Application Number: 2013-098

Project Name: Office to Apartment Conversion

Address: 531 CONGRESS ST

To: FILE
From: Shukria Wiar
Subject: Application ID: 2013-098
Date: 7/18/2013

**A1.0**

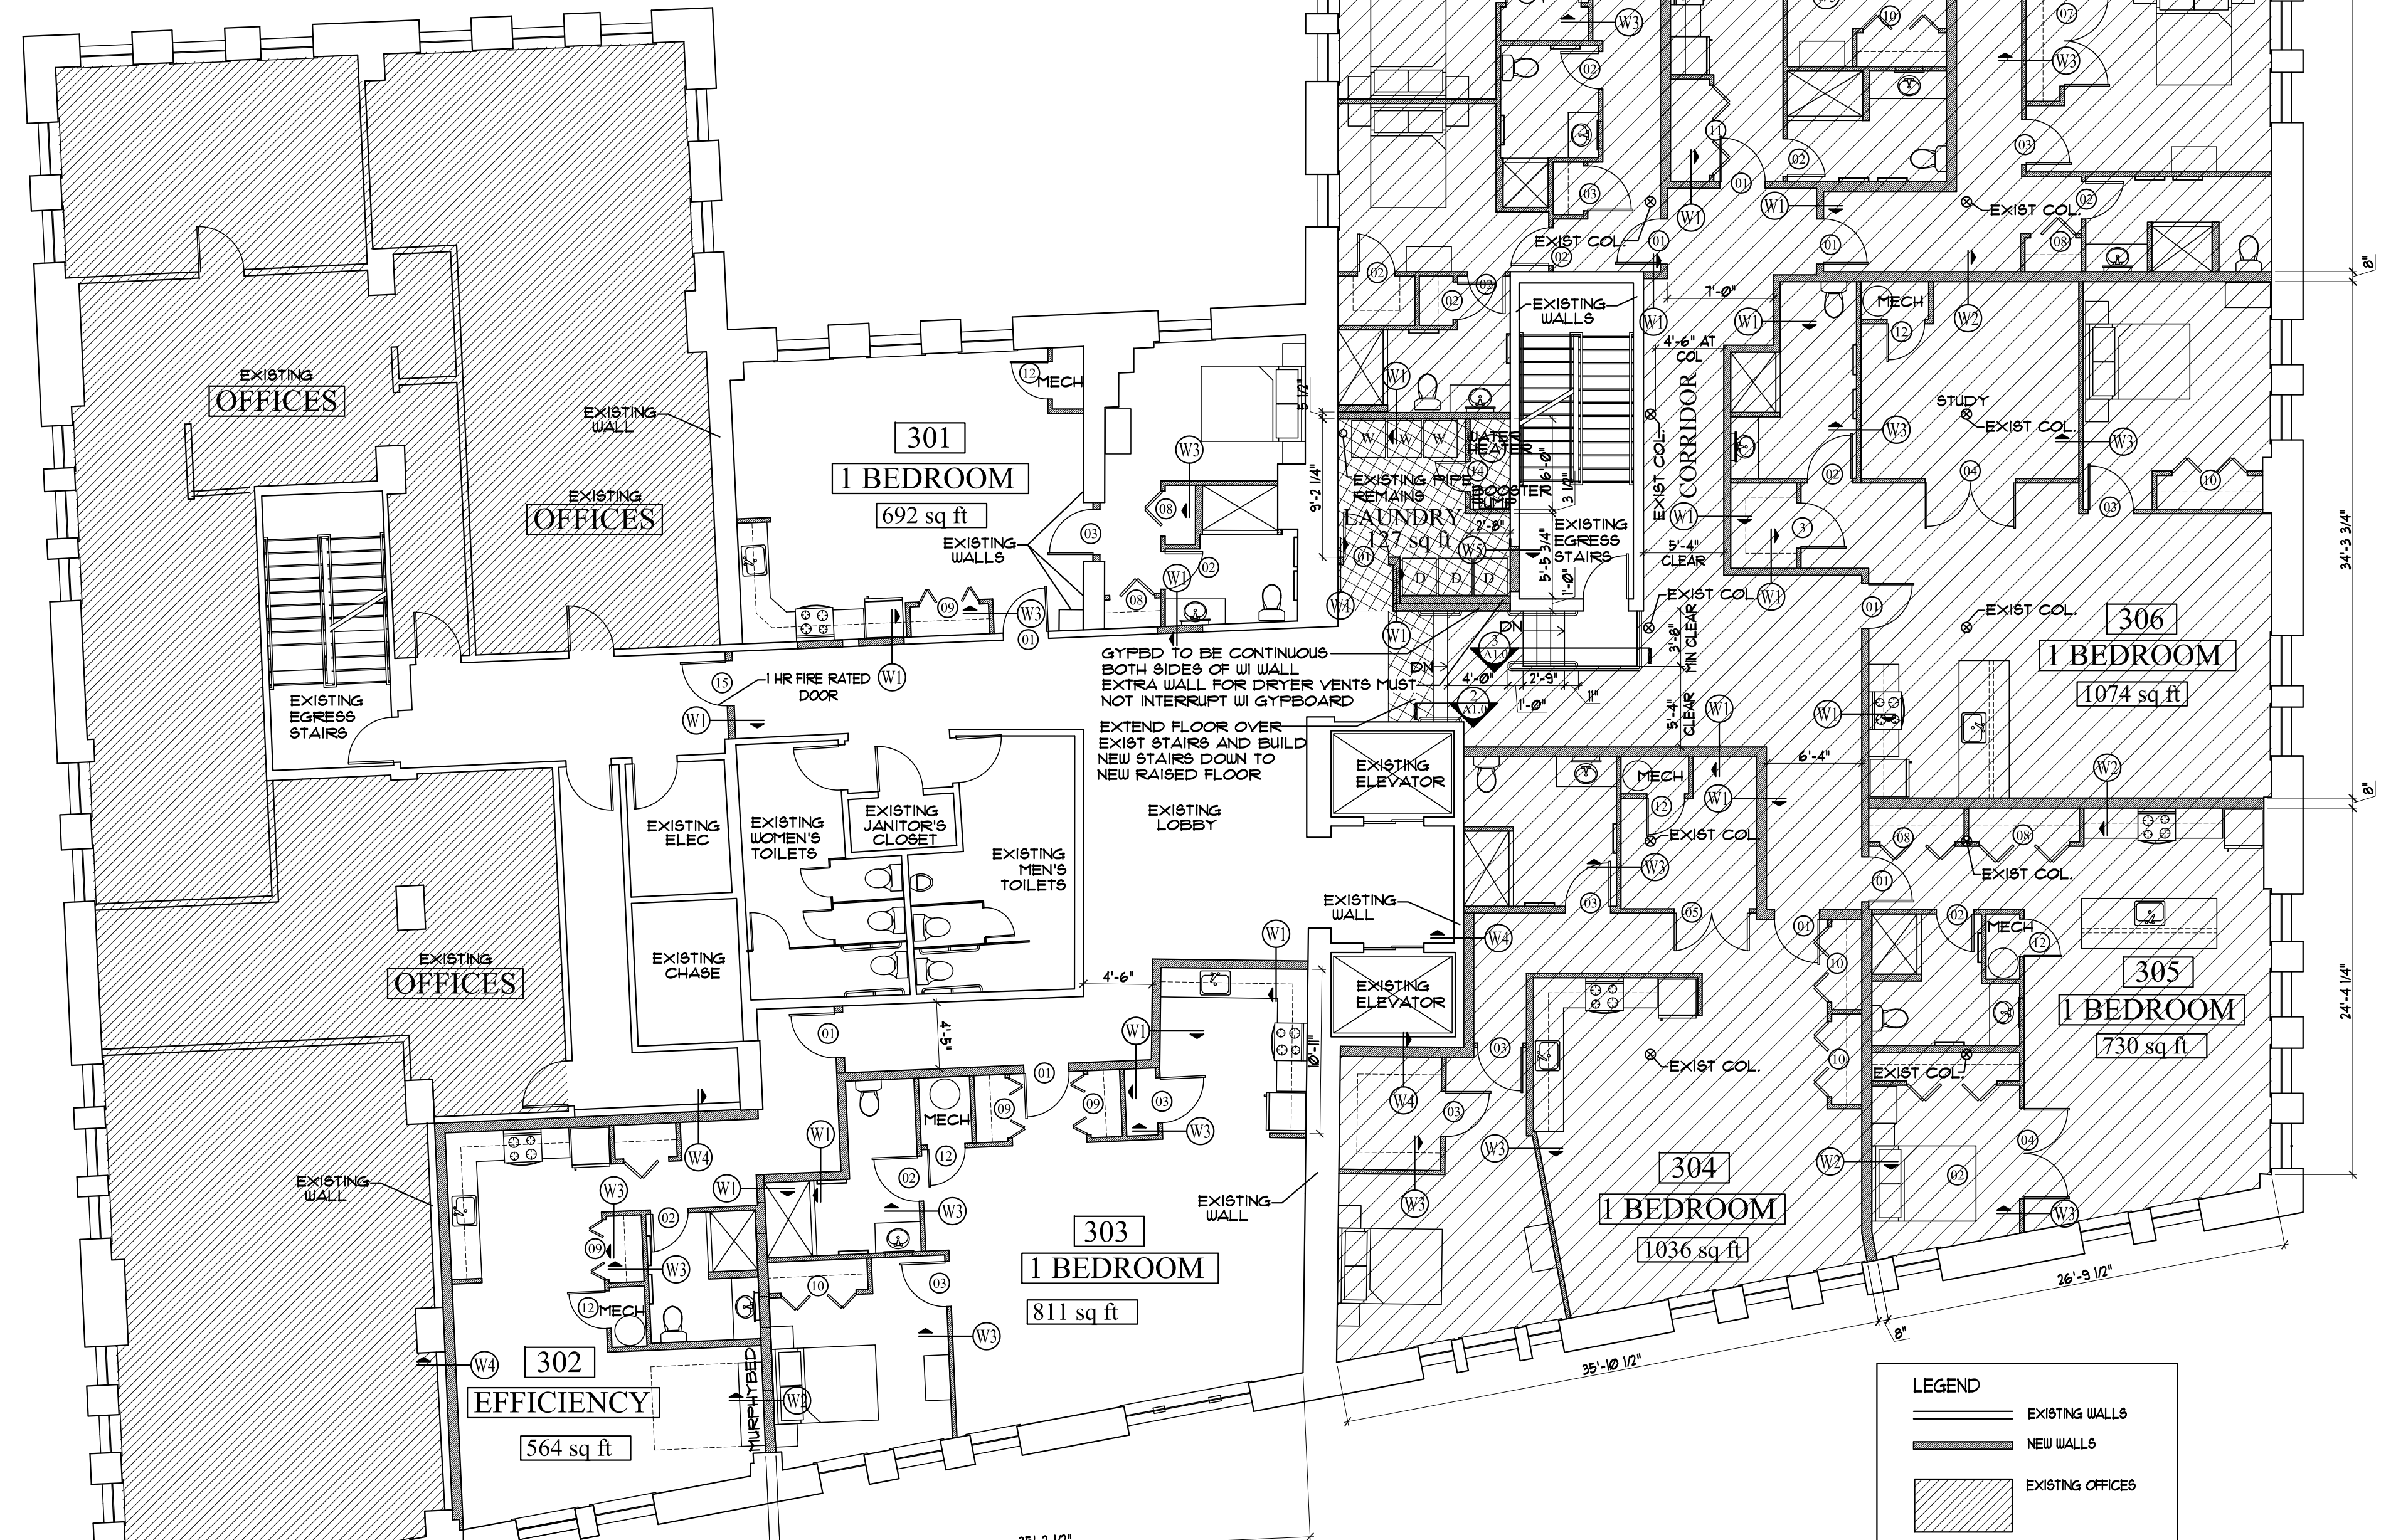
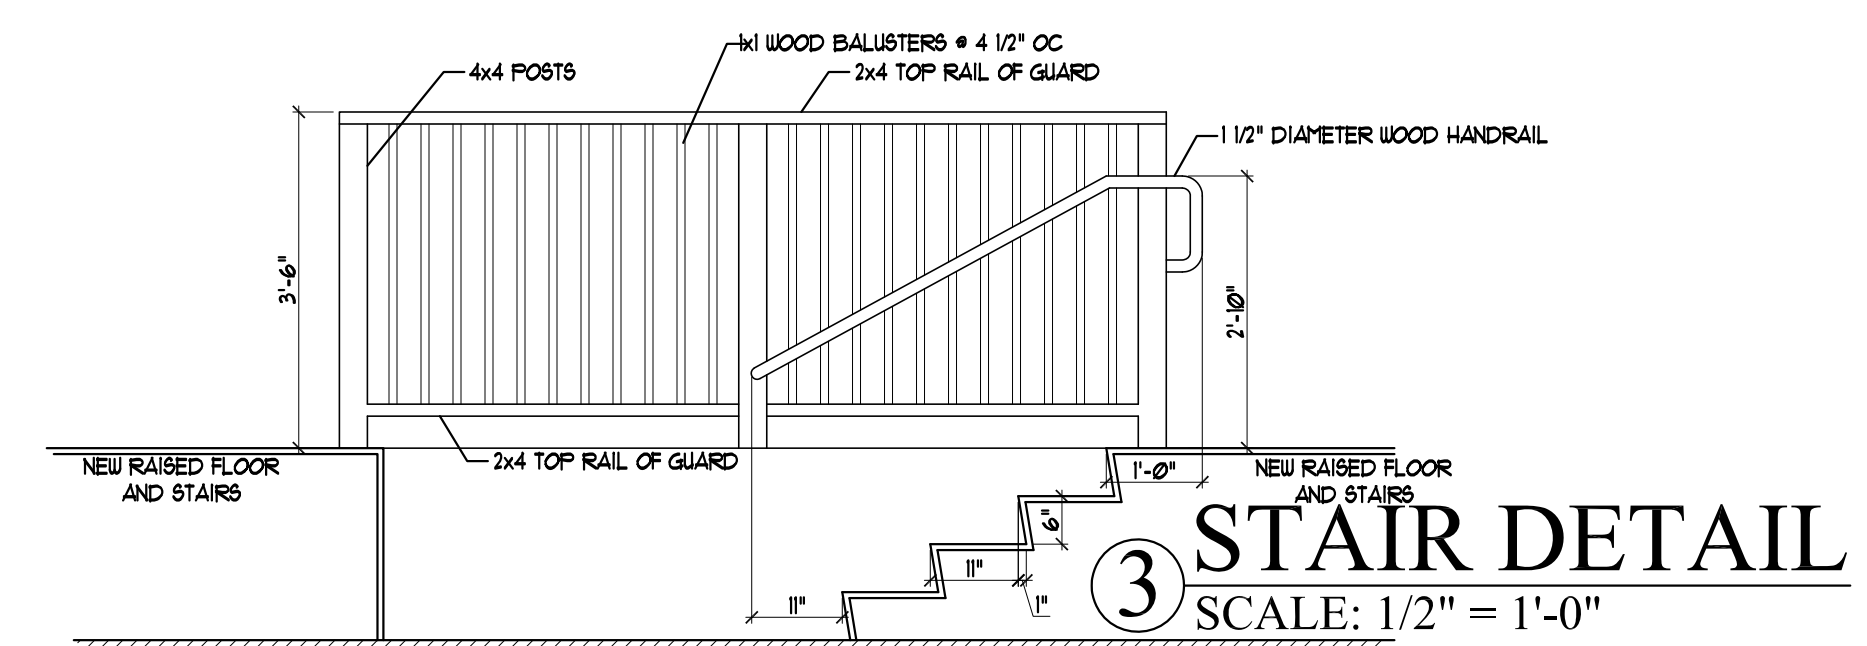
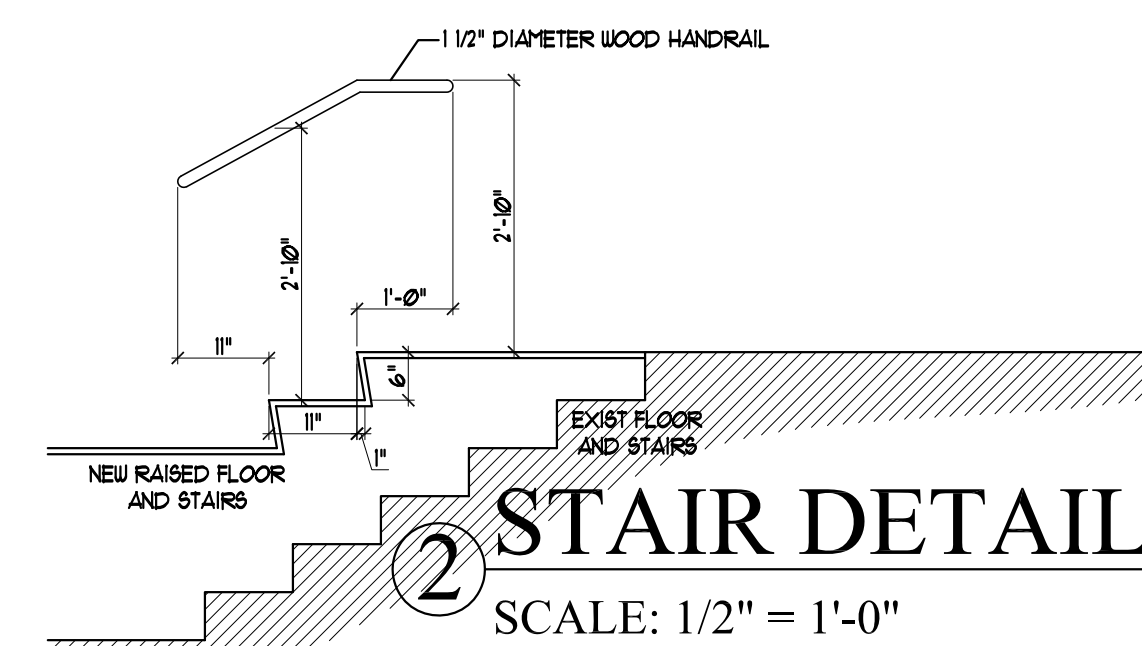
I do have a question as to the change of use. The narrative says the third floor will be changed from offices to 9 residential dwelling units. Yet the submitted plans show that some office space is to be retained.

Are some offices still to be retained on the third floor?

Also the floor plan submittal is labeled "option B". Is this the final plan or is there an option "A"?

Yes, for now but probably not in the future.

Not sure about this? What is option A and B?

The 3rd floor will be 9 residential condo units with some office space (3,000 sf) that will probably be converted into 2 or 3 more residential units

**A1.1**

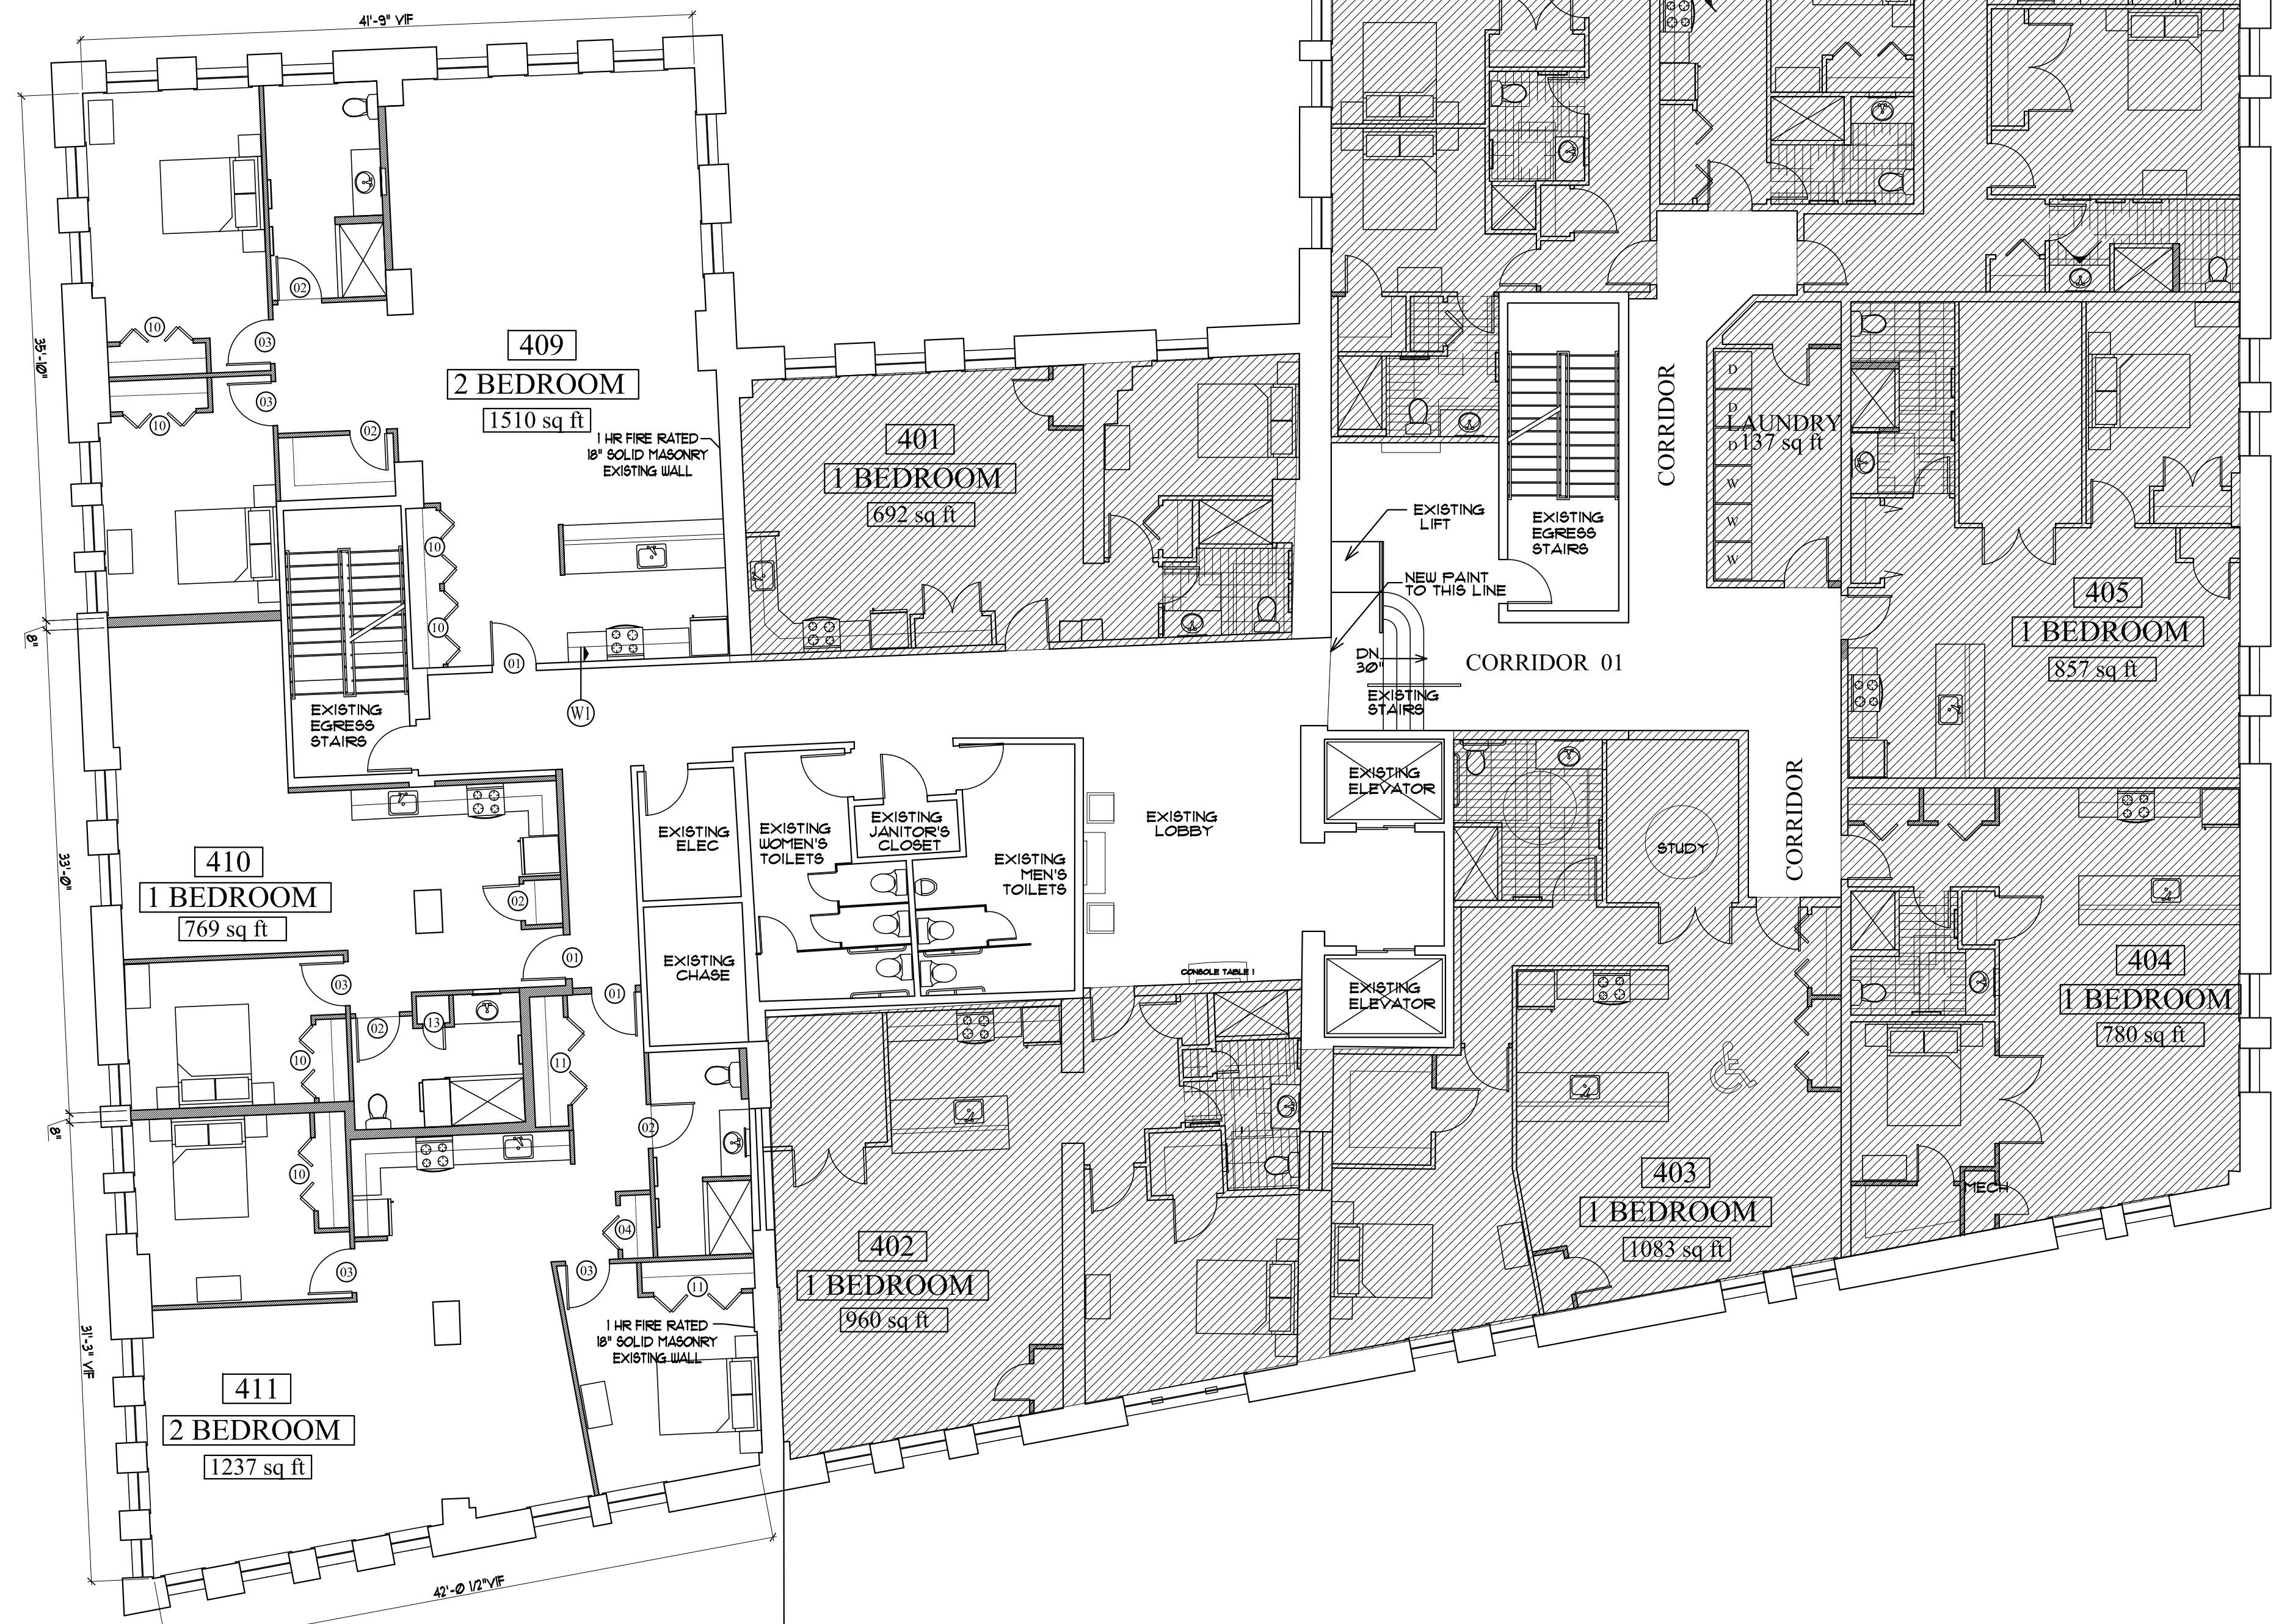
There has been some additional information that has been submitted. There has not been any written information that I can find that responds to my original questions. The new plans for the 3rd & 4th floors show that the applicant is now proposing 6 more dwelling units - 3 more on the 3rd floor eliminating any offices and also 3 more on the 4th floor for a total of 15 new dwelling units not 12 as somewhat indicated on a submitted application.

I reviewed the most current plans uploaded into E-Plan on 7/10/2013. The plans explain the situation much better. There will be 9 new residential condos on the 3rd floor with some office space to be retained. The 4th floor will add 3 new residential condos (eliminating all the existing office space) to the already existing 8 residential condos. Therefore, this project request is for 12 new residential condominiums.
